Our Ref: NW/ARU/16/05C

Date: 19th February 2019

RE: Land South of Burnell Road

In regard to your query I make the following recommendations regarding the proposed lighting plans 111.15_105A External Lighting Scheme Site Wide Elements and 54_15_105 External Lighting Scheme.

HALF LANTERN BLACK LED 600 HILO

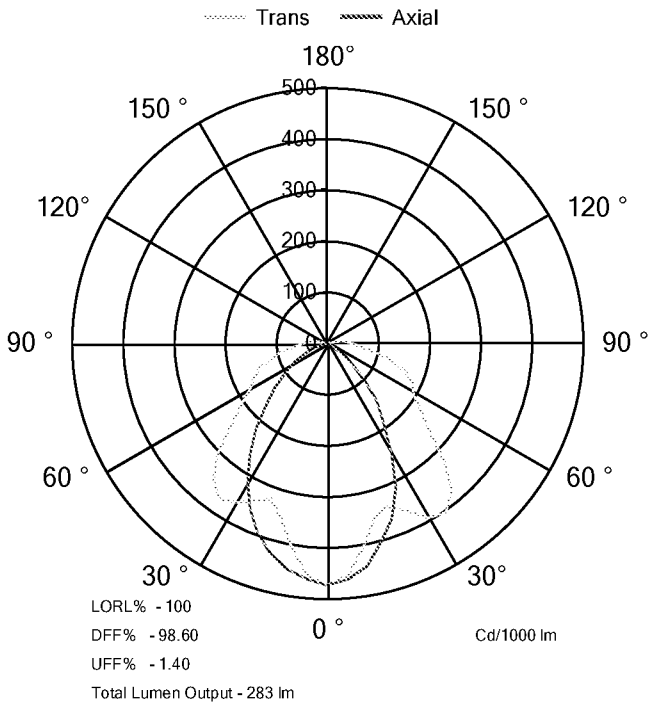
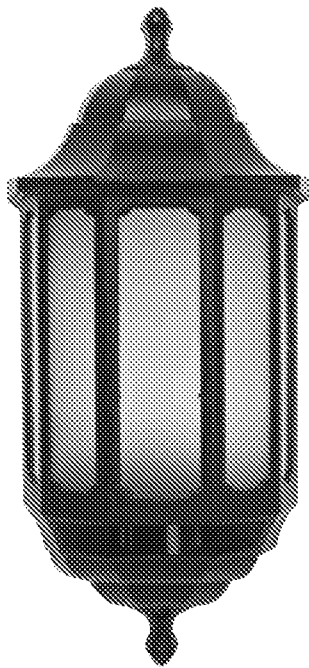
Compliance with BS5489:2013 ensures an overall light level is achieved (SBD Homes 2016 Chapter 18 gives further guidance). It also states in SBD Homes 2016 Chapter 18.3 that 'Bollard lighting is not compliant with BS5489:2013 because it does not project sufficient light at the right height and distorts the available light due to the 'up lighting' effect, making it difficult to recognise facial features and as a result causes an increase in the fear of crime.

From a 'crime prevention' viewpoint I have concerns that for reasons mentioned above the 8 lighting bollards that are indicated on the plans will not be sufficient, (in number or location) and are inadequate to provide sufficient observation for road users during late evenings, early mornings or at night, to help reduce fear of crime, and that shielding around light sources may achieve sufficient reduction of stray light, using conventional light columns conforming to BS5489:2013.
